Please find attached our revised drainage calculations and report as discussed on Friday (see above email chain) regarding Pound Place (Planning Consultation ref A/161/19/DOC).

We have been forwarded your email by Shivani and I have spoken with Sarah Burrow (Engineering Assistant) who drafted the request for clarification and/or further information regarding Pound Place (Planning Consultation ref A/161/19/DOC). Our response follows the same order as per her comments (email dated 20/11/19):

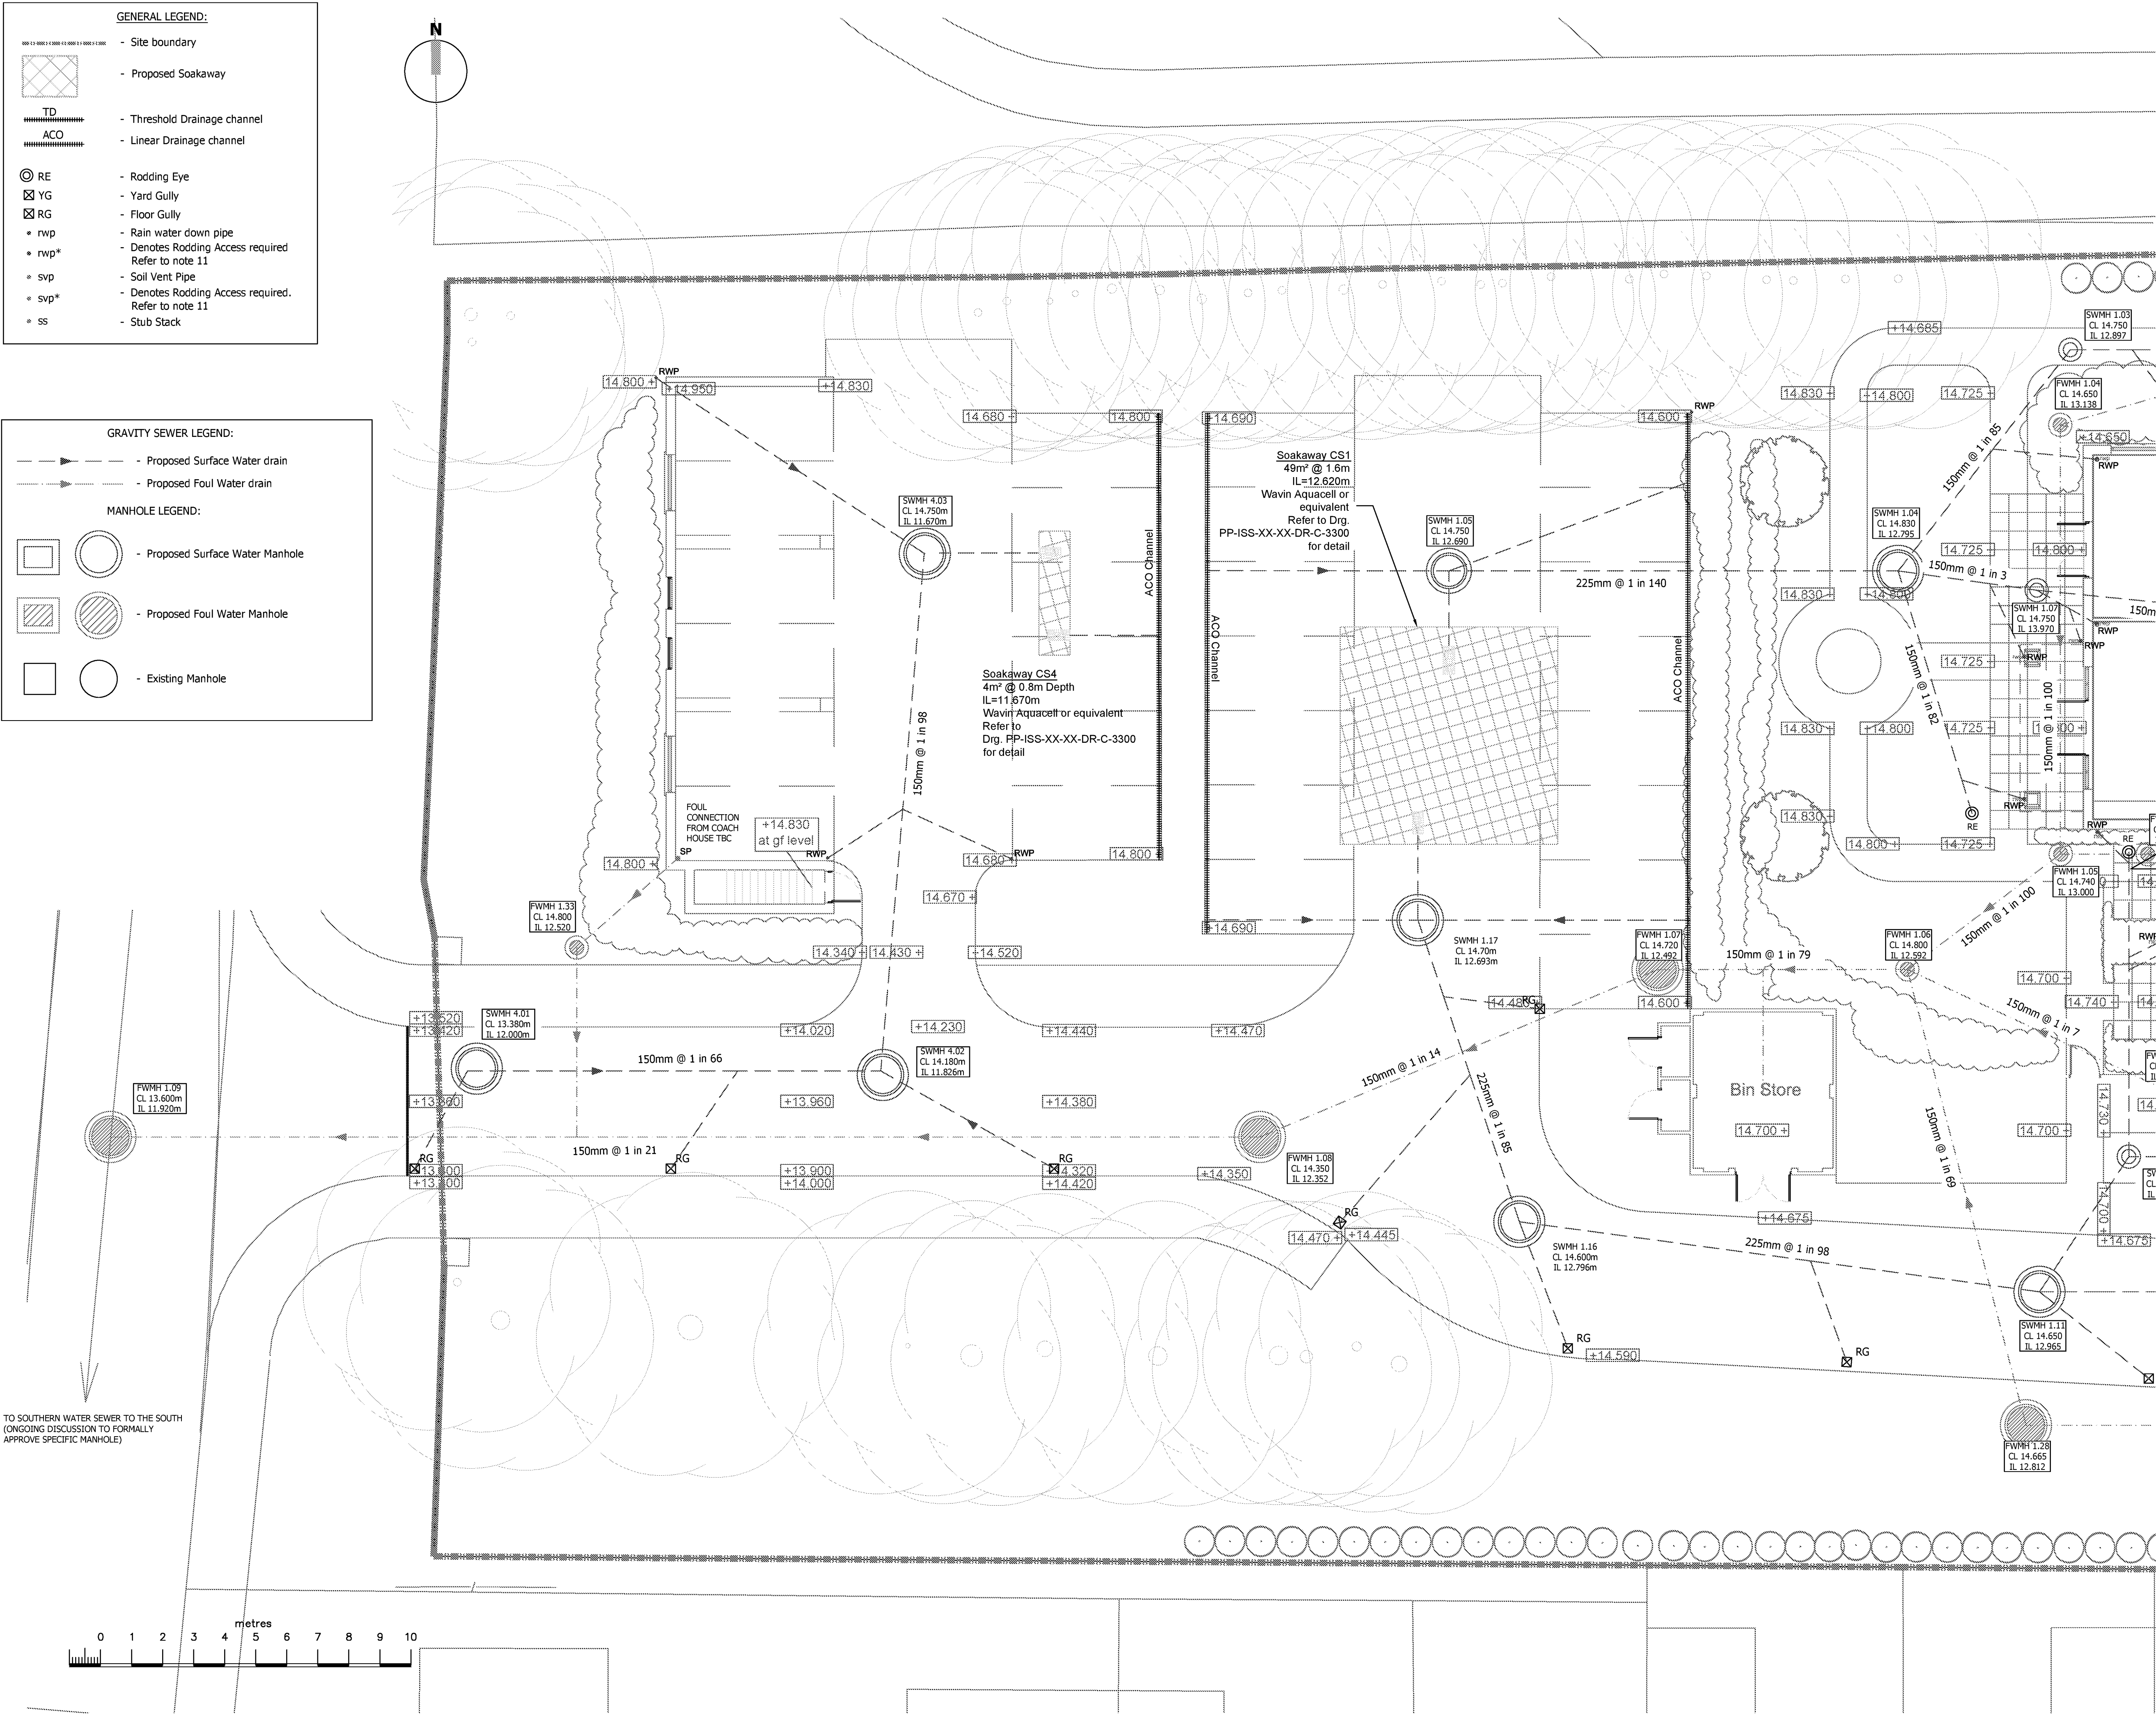
3 - The permeable paving mentioned in the DDSR (Section 6.3) was removed during the design development. Sarah has expressed concerns if water quality still can be achieved with the removal of this SuDS tool. The Client has agreed to introduce permeable paving to the parking bays to the west, providing the requested water quality treatment for the western road and parking areas surface water runoff. As noted above we are updating the model and will issue Monday.
